From: Cherne, Curtis
Sent: Friday, September 05, 2014 3:53 PM
To: Quintana, Carol S.; Connor, Francis
Subject: 901 Park Ave SW (Silver Moon Apt) Phase 1 Perm CO approval

Hydrology is approving a Permanent CO for Phase 1 at 901 Park Ave SW (Silver Moon Apts).

**Re: Silver Moon Apartments
10th St & Park Ave.
Request Permanent C.O. – Not Accepted
Engineer's Stamp dated: 5-1-13 (K13D072)
Certification dated: 8-12-14**

SILVER MOON LODGE
10TH ST. AND PARK AVE.

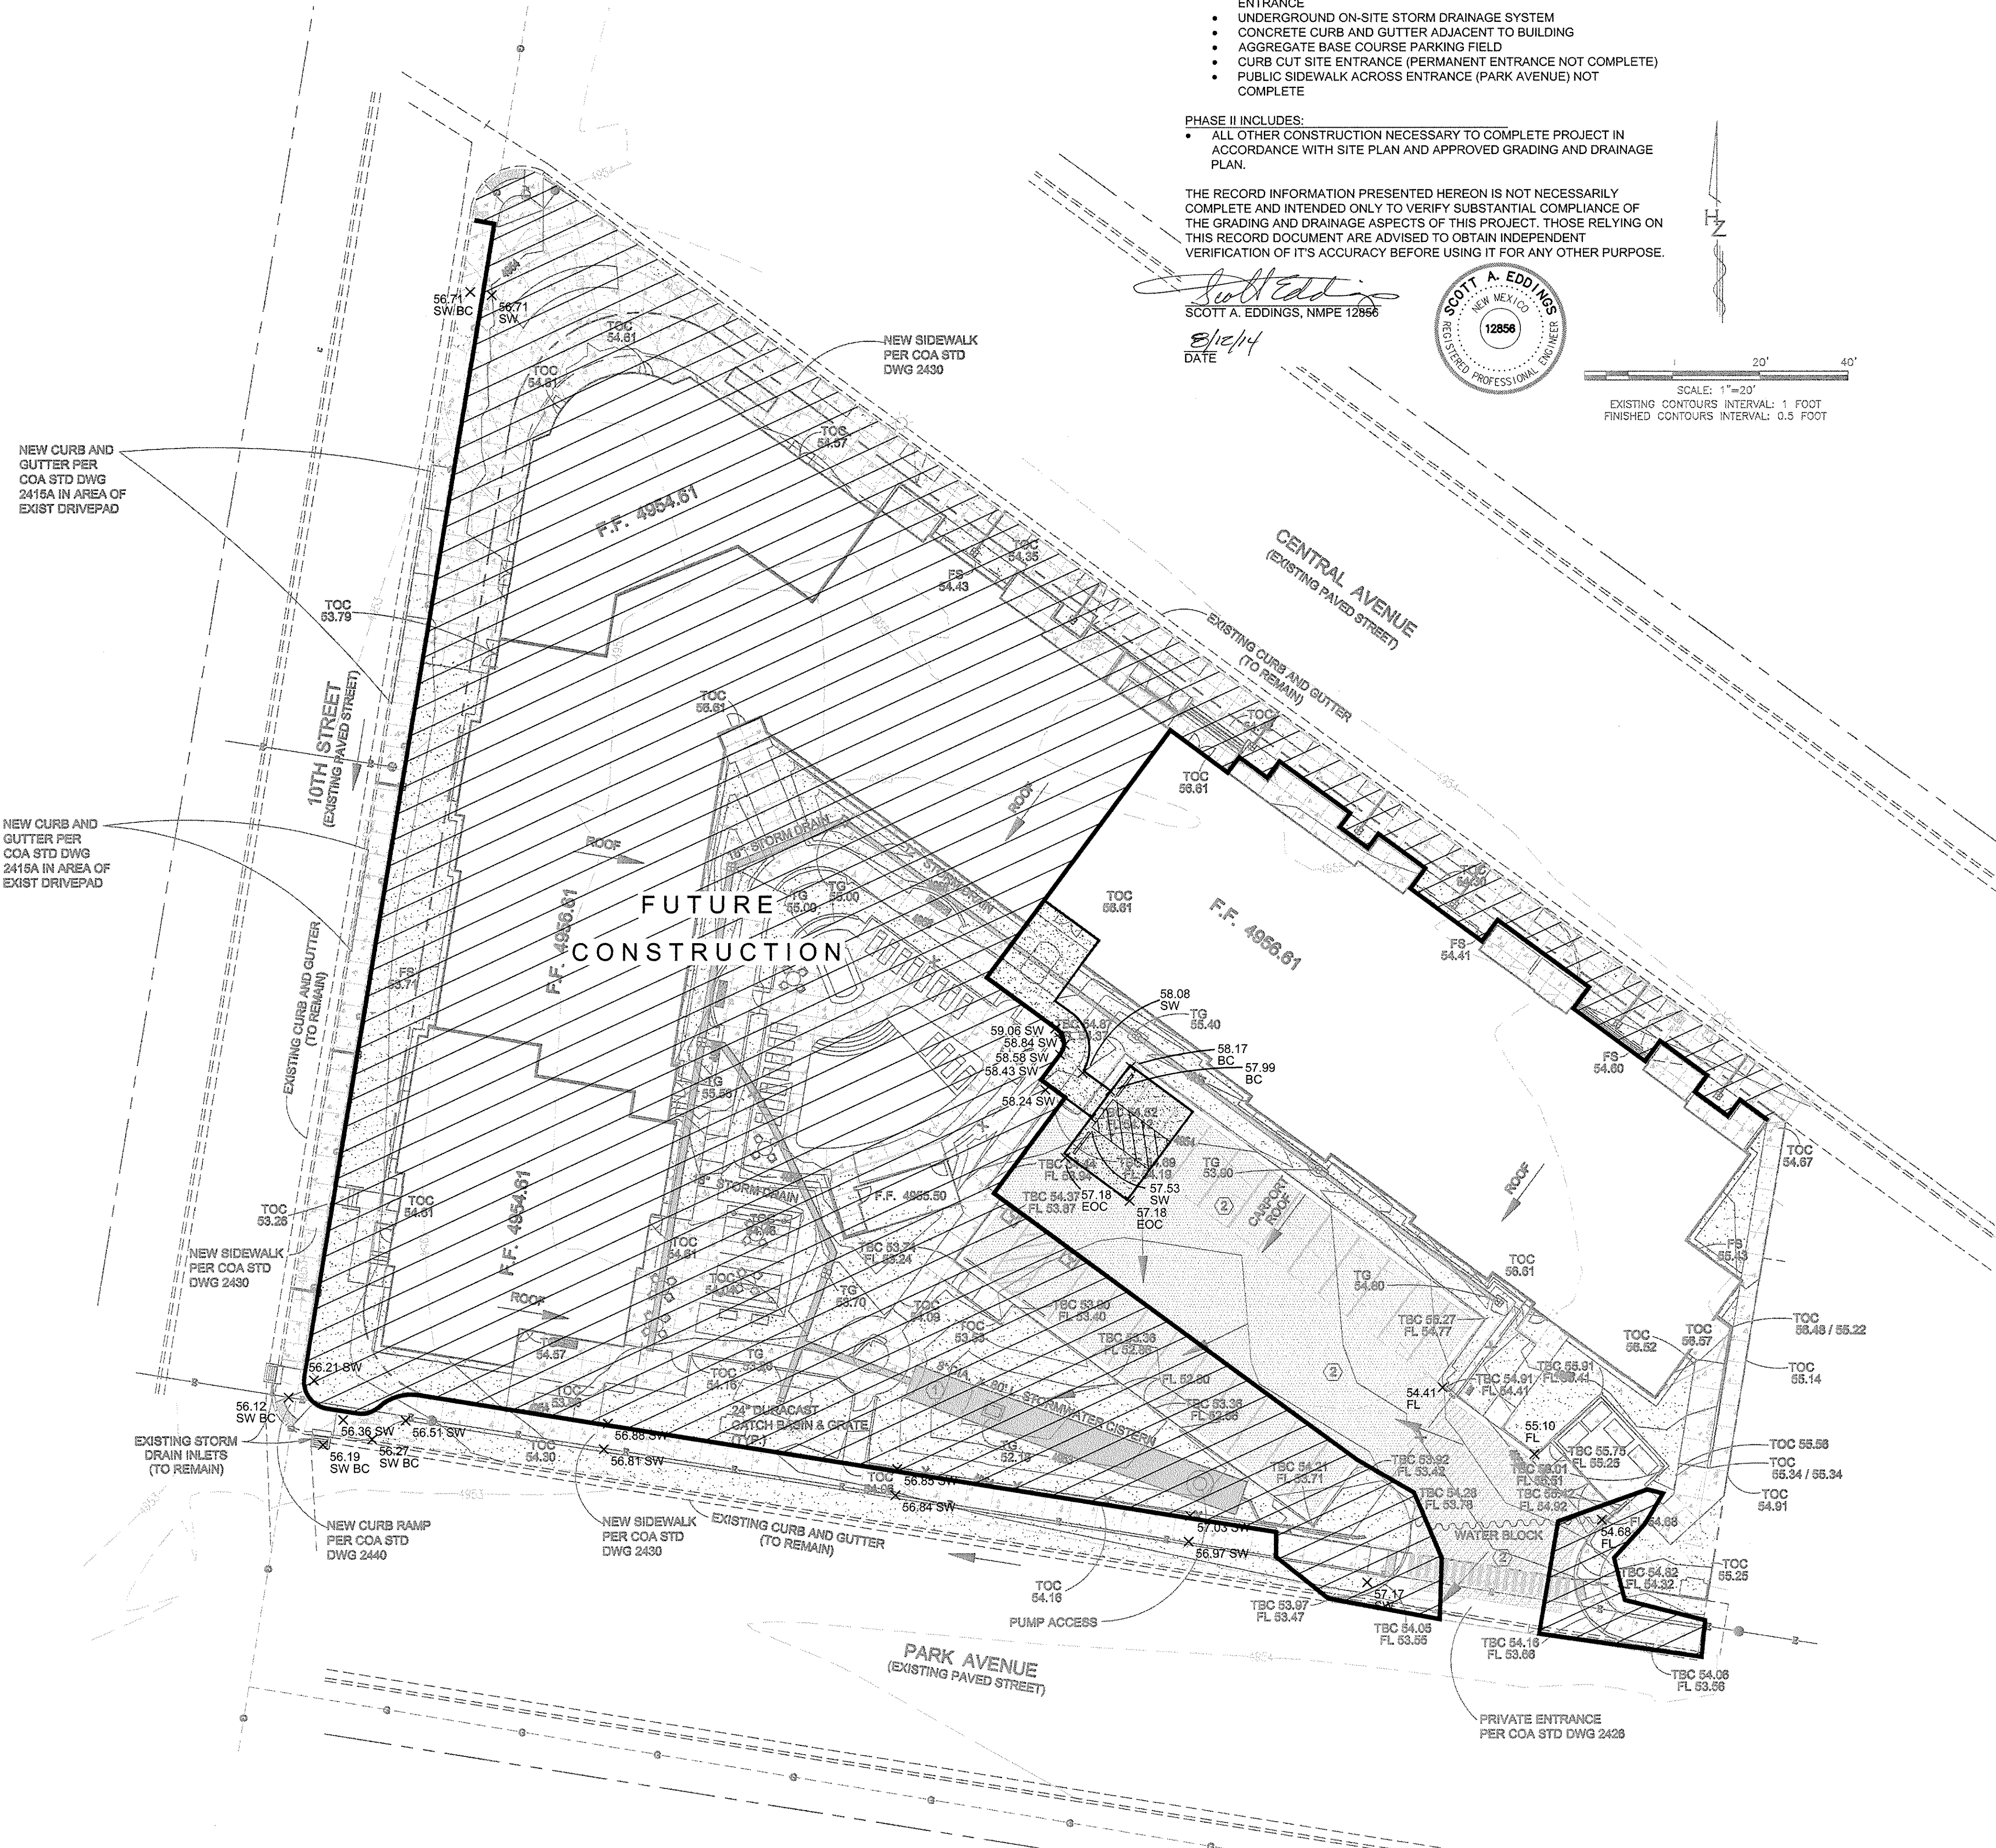
- The plan submitted for CO does not match the approved Grading and Drainage plan.
- We cannot give a partial CO, when the entire site was submitted under one building permit and not in phases.
- The site does not drain in substantial compliance.
- The drainage certification language does not match the hatched areas given on the plan.
- The site is a concern for the safety of its patrons.
